Heckington Fen Solar Park

EN010123

Statement of Common Ground with Natural England

Document Reference: 7.6i

| Condense / Sho | ow Columns Cond | ment Idense / Show Rows Instructions | | | | | | | | | | | | | | | | | | | Change in broad | d habitat type dete | cted. Check compliance with guidance. | | | | | | | |

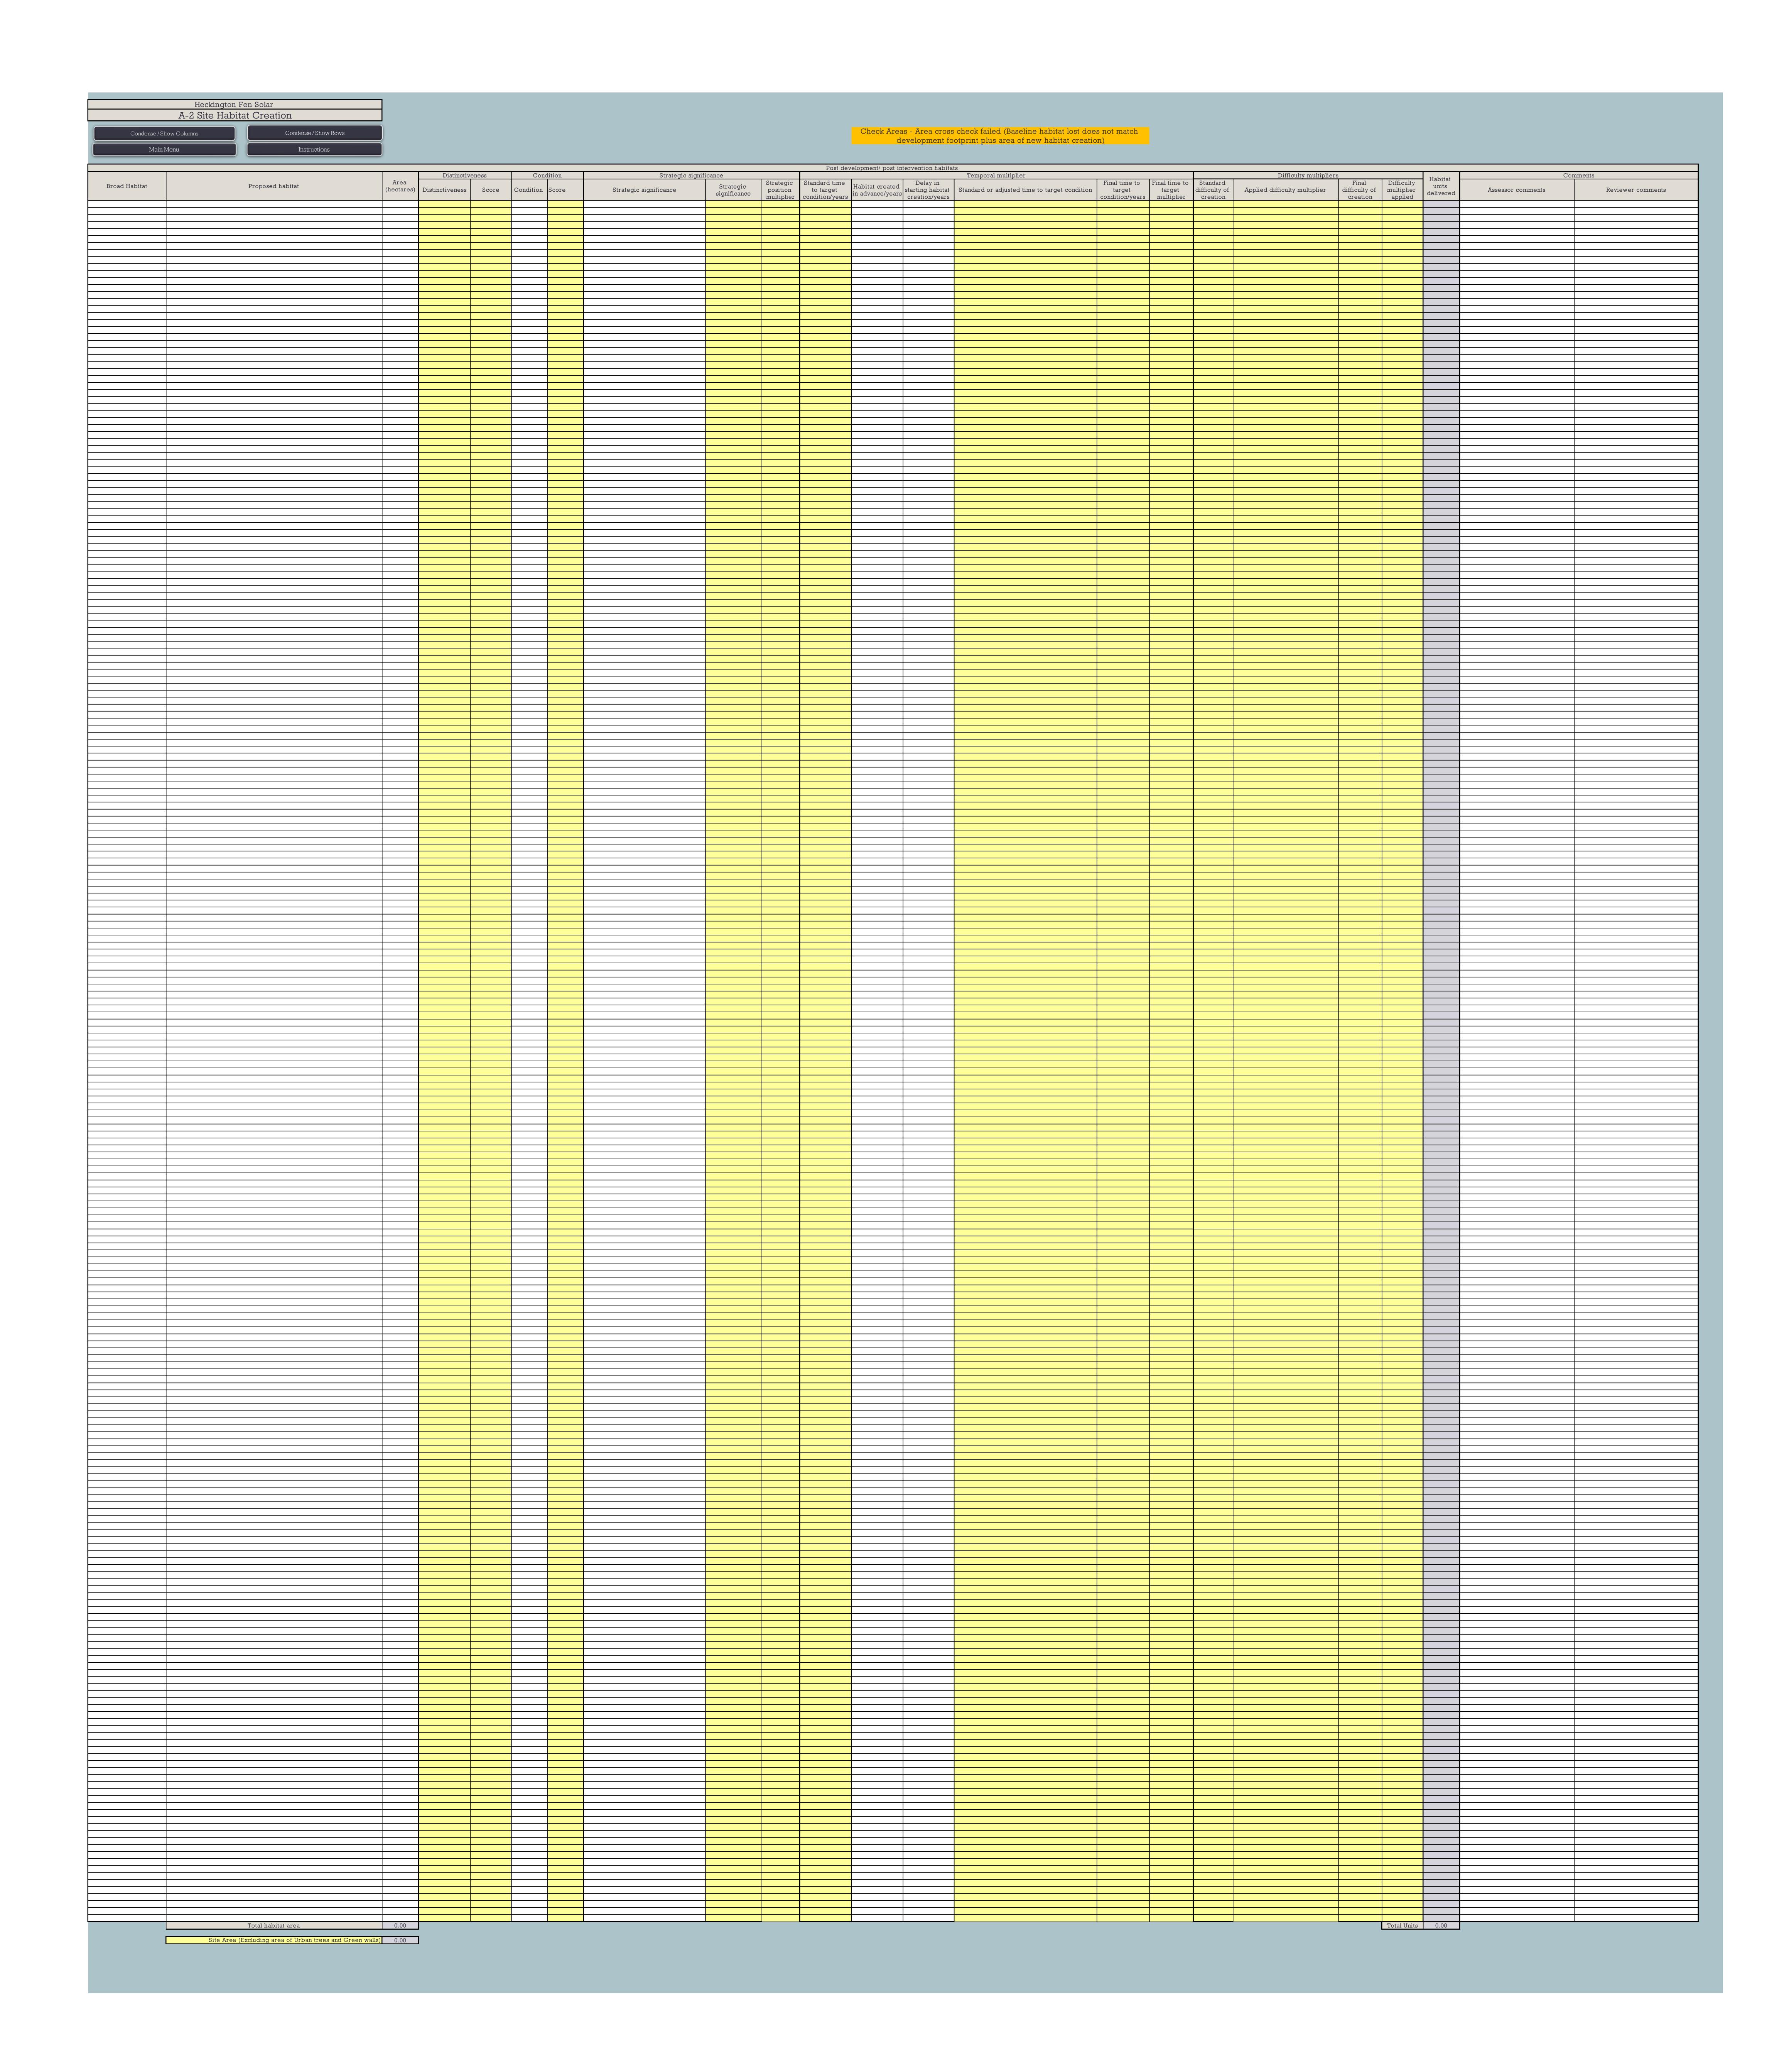
6. Biodiversity Net Gain			
6.1 Under	Biodiversity Net Gain	NE welcomes the commitment to deliver BNG	The Applicant notes NE's comments made

Reference and Status	Topic	NE’s Position	Applicant’s Position
DiscussionAgreed	Metric 3.1 used (Appendix 8.12) provided to NE on 20 th June 2023.	and is generally supportive of the enhancements proposed through the development. The enhancements detailed within the oLEMP, are welcomed and are likely to indirectly have a positive effect.	in relation to BNG during consultation which are generally supportive of the enhancements proposed, and detailed in the oLEMP.
